Your 3/2020/0112
ref
Our ref 23rd March 2020
Date

Dear Sir
Application no: 3/2020/0112
Address : Glencroft Pendle Avenue Chatburn
Proposal: Demolish existing and erect 2 replacement dwellings

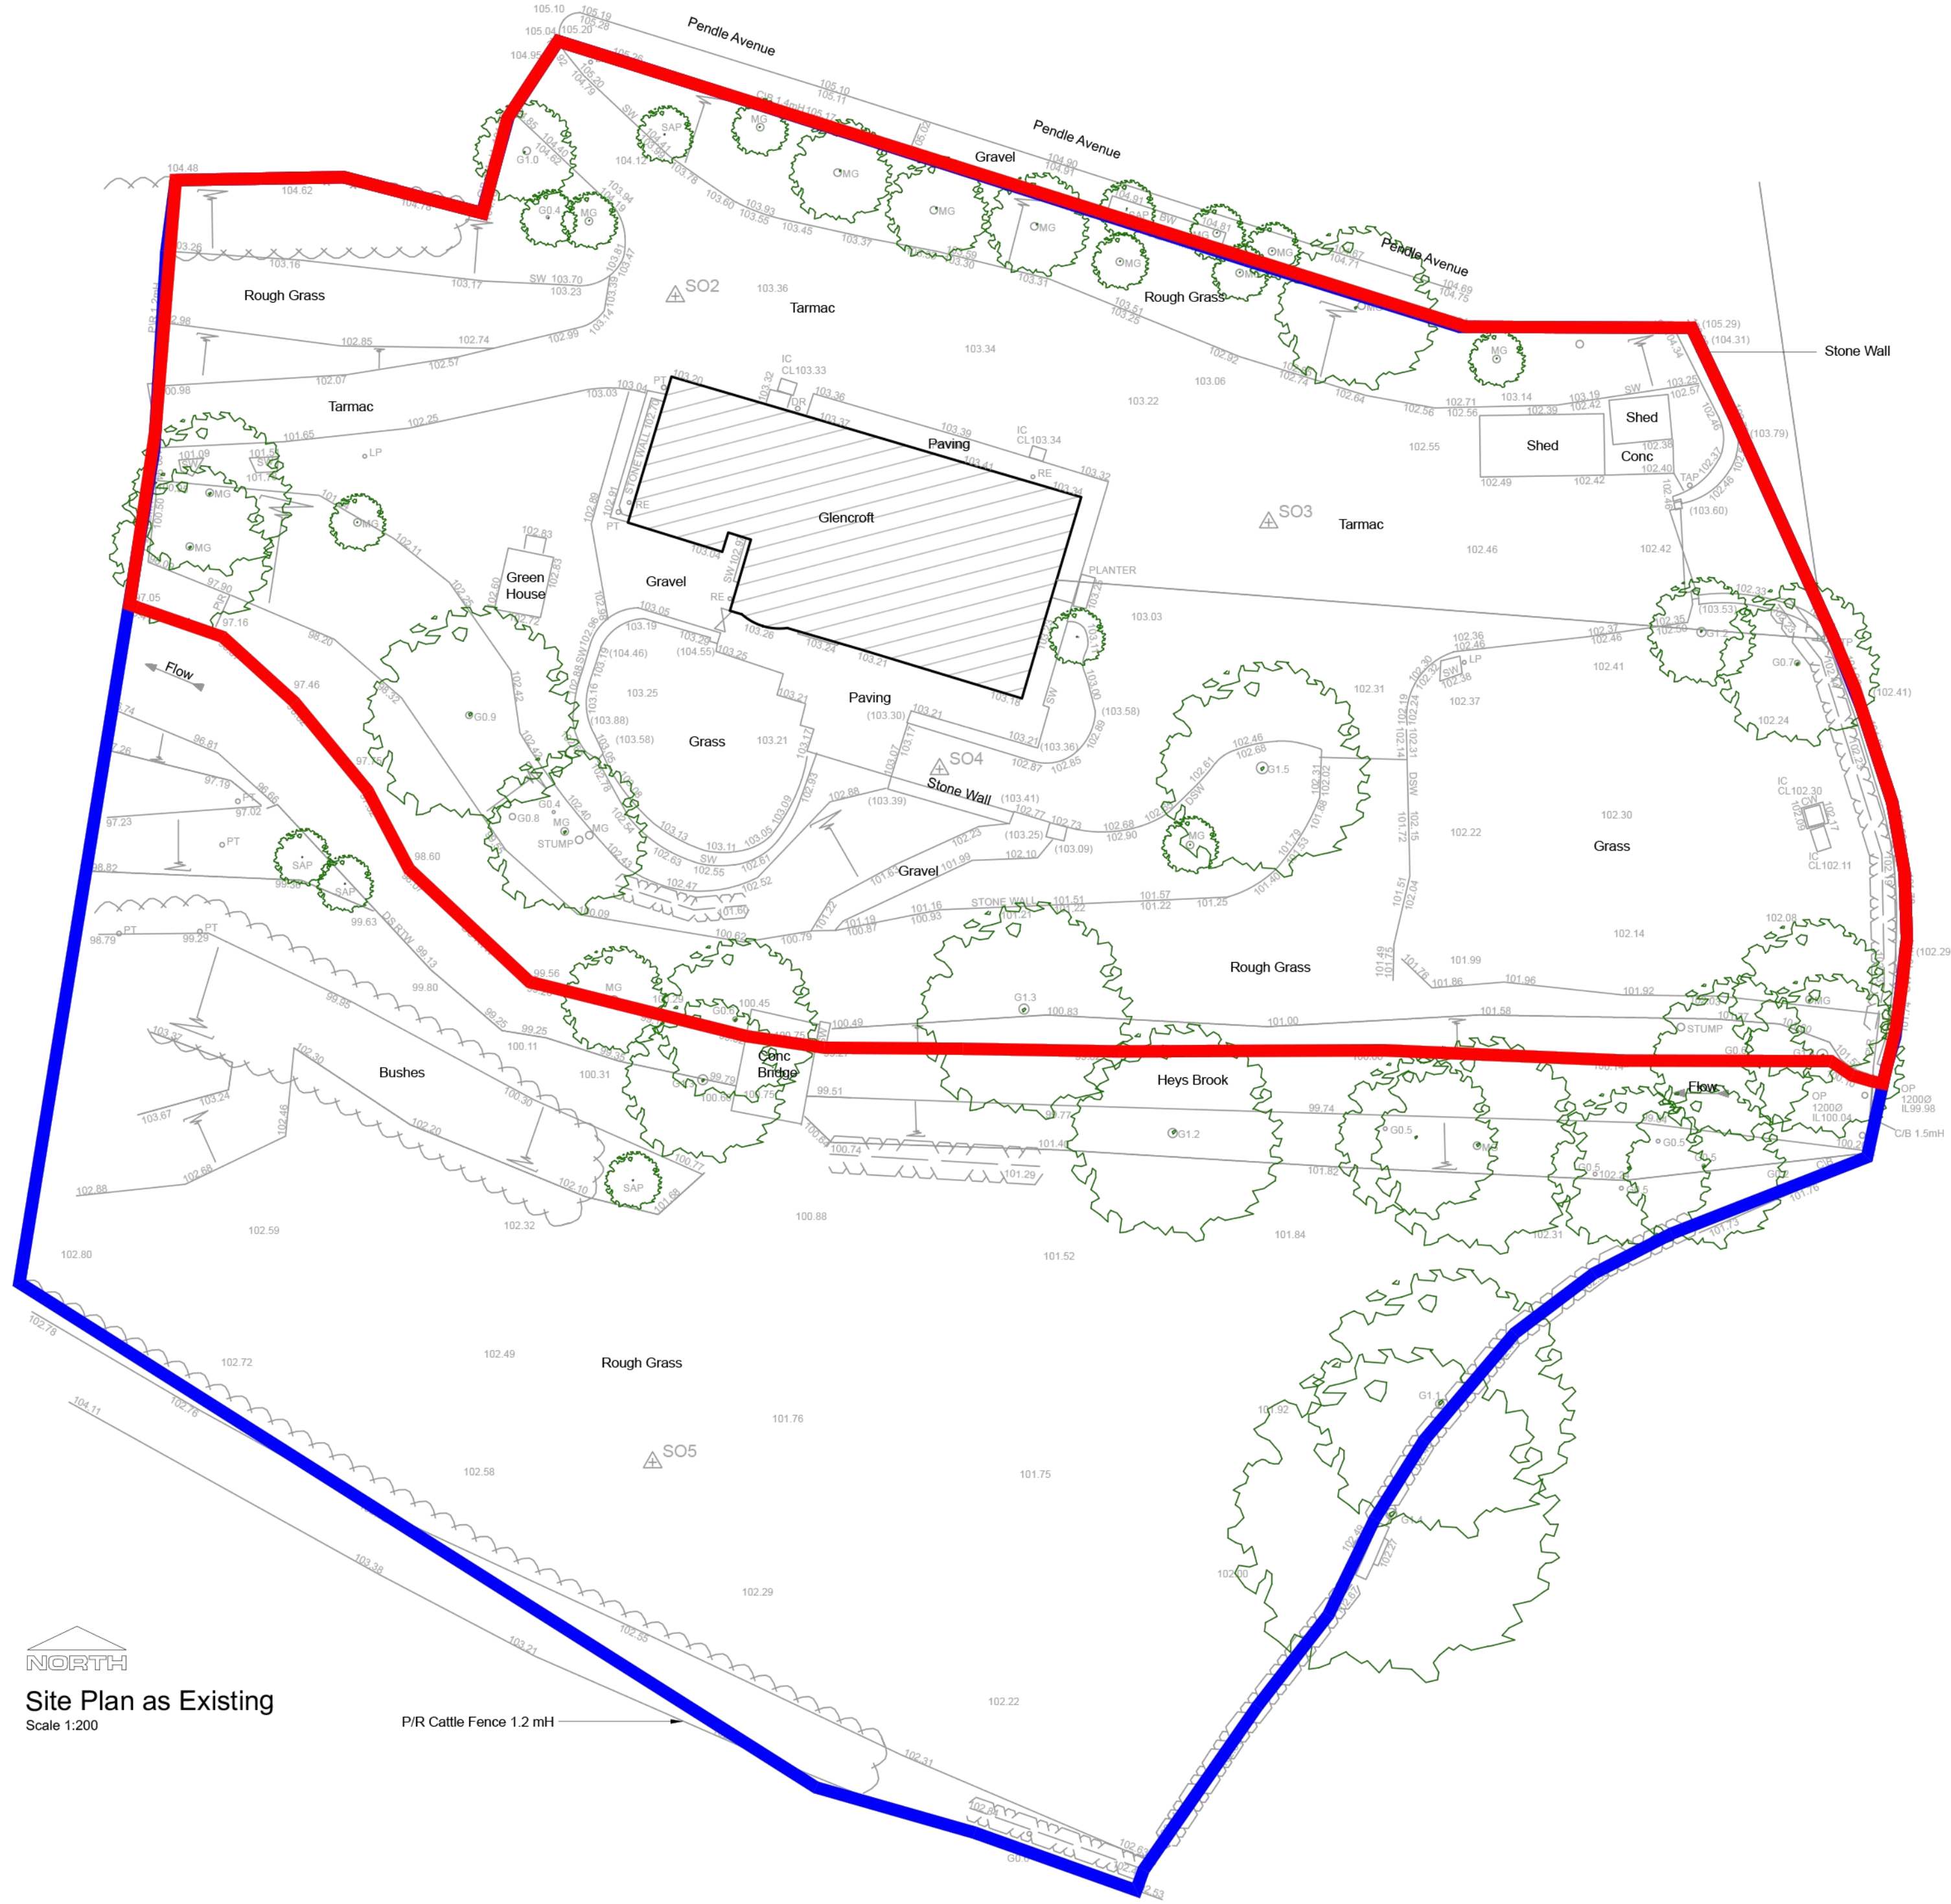
The proposal is for the demolition of the existing building and the erection of 2 new detached dwellings. Whilst the proposal is unlikely to result in any highway concerns clarification of the parking provision is required for the easterly dwelling. Currently the dimensions of the integral garage would serve only 1 vehicle. The forecourt area is restricted and will make it difficult to enter and leave the 2 spaces available when parked in the manner shown on the site plan. I would therefore request that an amended plan be submitted to address this issue.
